CLAREMONT BUSINESS PARK 2 FIL. NO. 1 - LOT 2

EL PASO COUNTY, STATE OF COLORADO GRADING & EROSION CONTROL PLAN

EPC STORMWATER REVIEW COMMENTS ARE SHOWN IN ORANGE BOXES WITH BLACK TEXT

GRADING & EROSION CONTROL PLAN
CLAREMONT BUSINESS PARK 2 FIL. NO. 1 - LOT 2
JOB NO. 44-037
DATE PREPARED: OCTOBER 9, 2020
DATE REVISED:

GRADING & EROSION CONTROL PLAN
CLAREMONT BUSINESS PARK 2 FIL. NO. 1 - LOT 2
JOB NO. 44-037
DATE PREPARED: OCTOBER 09, 2020
DATE REVISED:

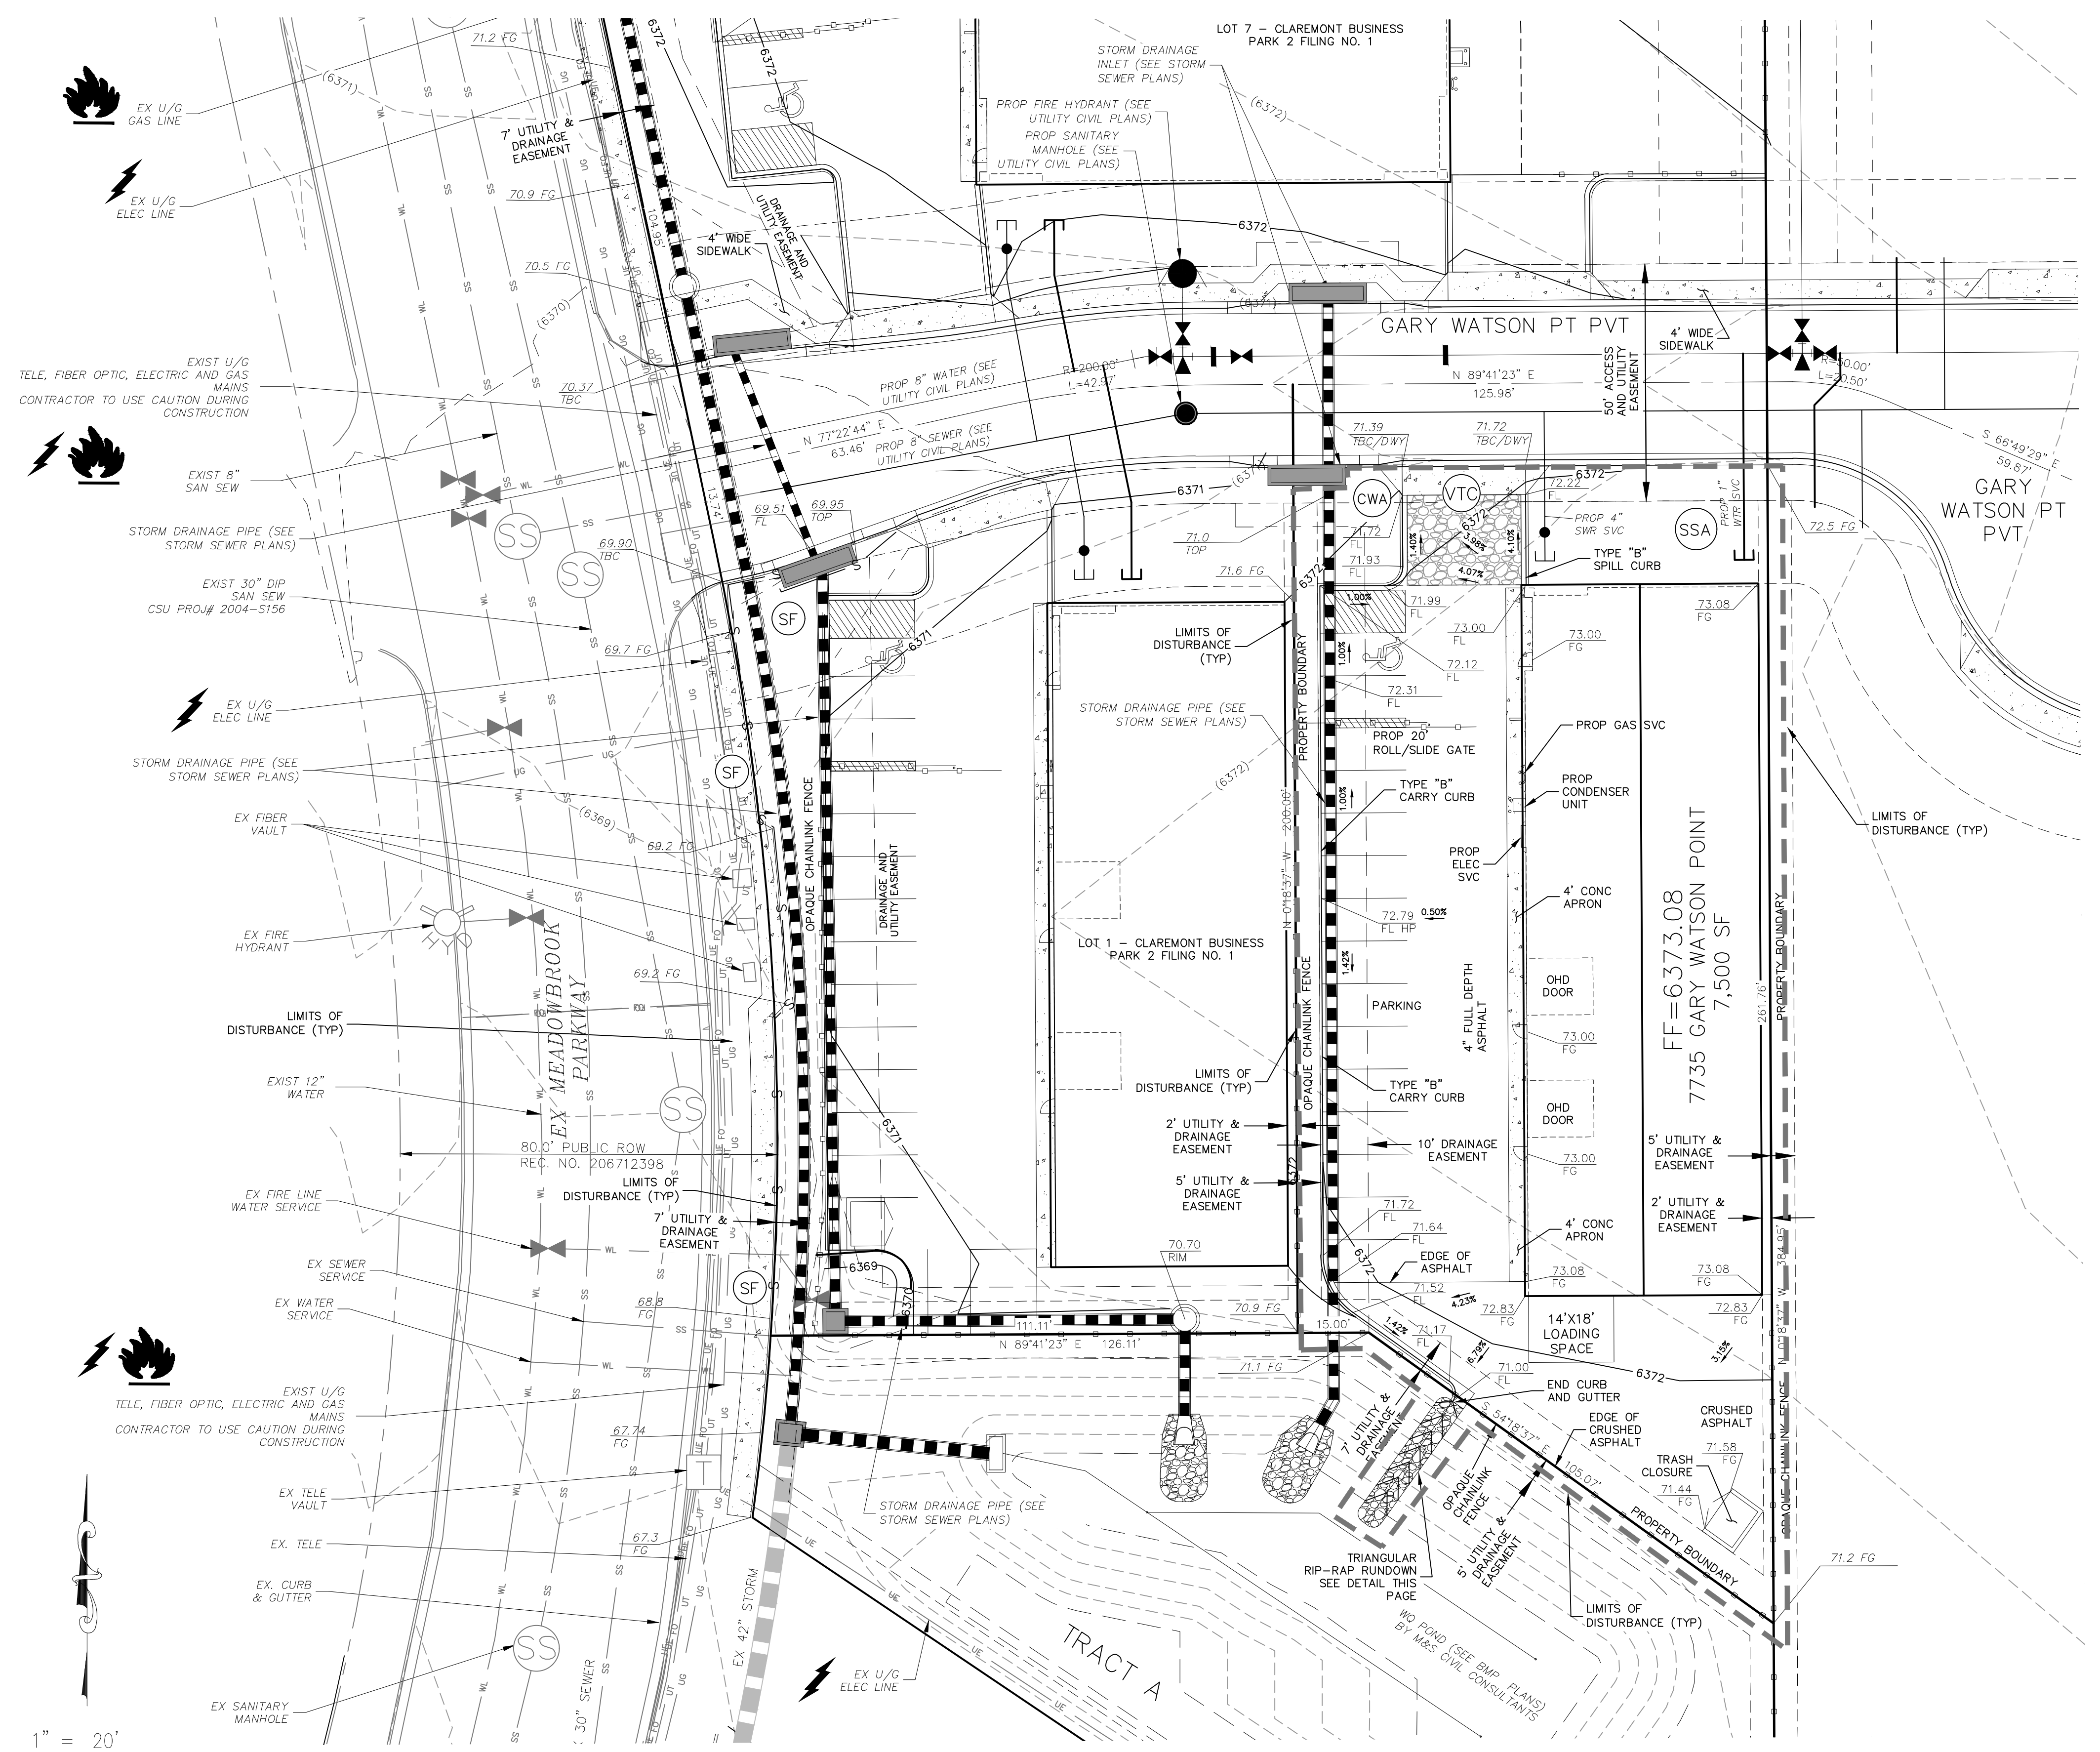
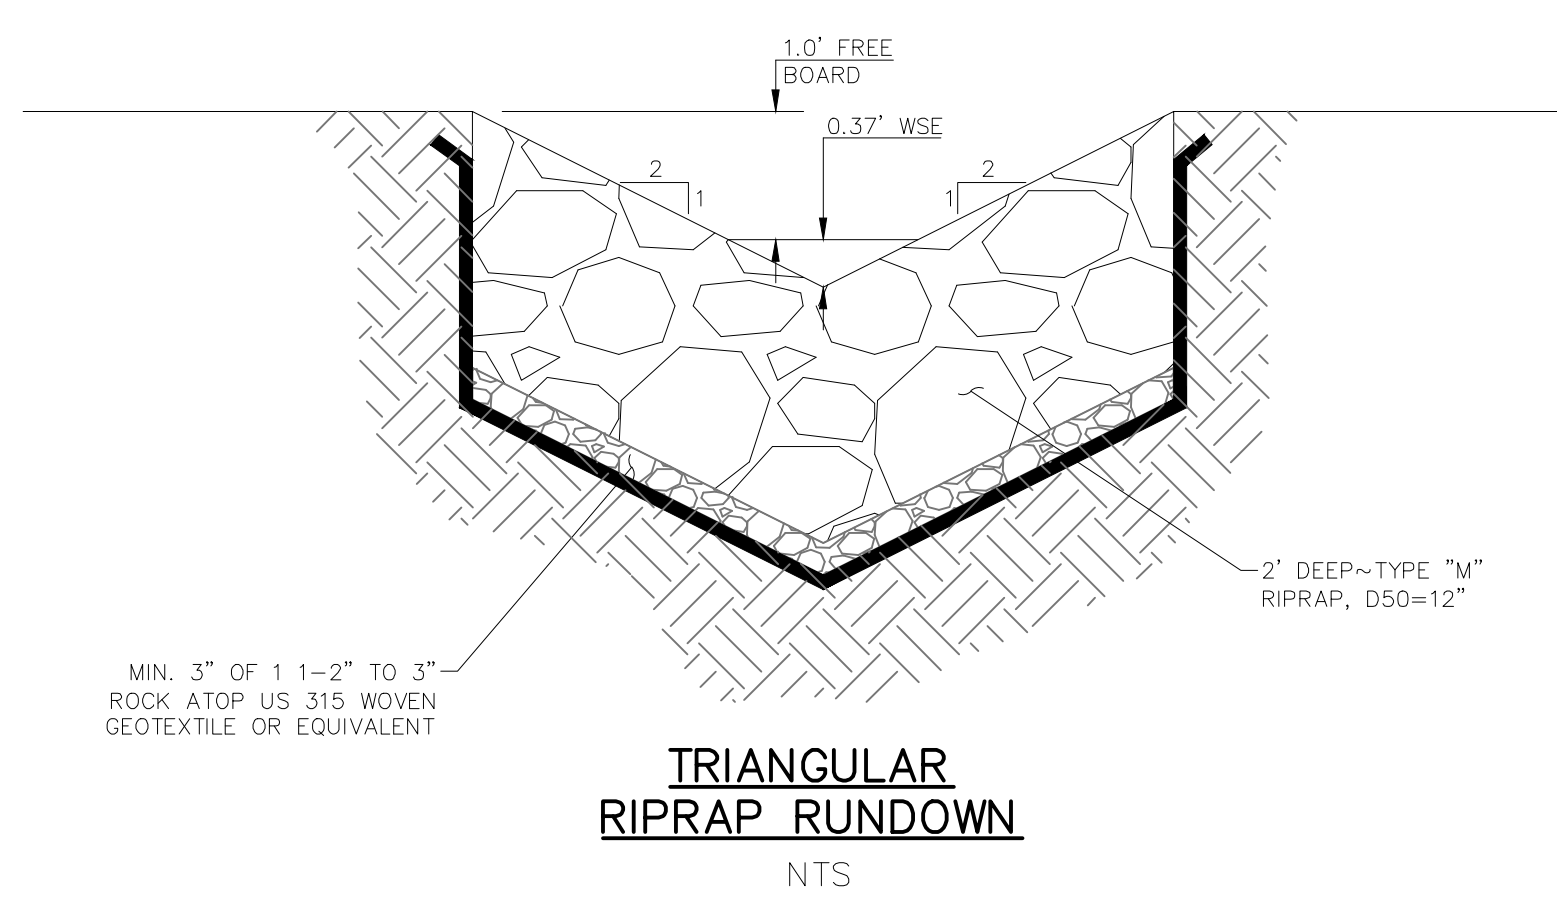
show silt fence locations on figure

Label all proposed temporary construction control measures by phase of implementation (initial, interim, final)
Provide BMP Details

If "limits of disturbance" and "construction boundary" are the same, change to "construction boundary/limits of disturbance" or otherwise show as separate line types for each on the legend and figure.

Provide riprap gradation table and note that CDOT Section 506 Requirements apply

Add a note about existing vegetation and percent cover (prior to early grading).
Add a note stating no asphalt/concrete batch plants are associated with this project.
Add a note stating there are no springs, streams, or wetlands at the Site.
Add a note stating that all cut/fill activities were completed under EGP204

Please show sidewalk going around the driveway, like in approved construction plans (SF-2014).

Please update plans to include width and length dimensions for the rundown.
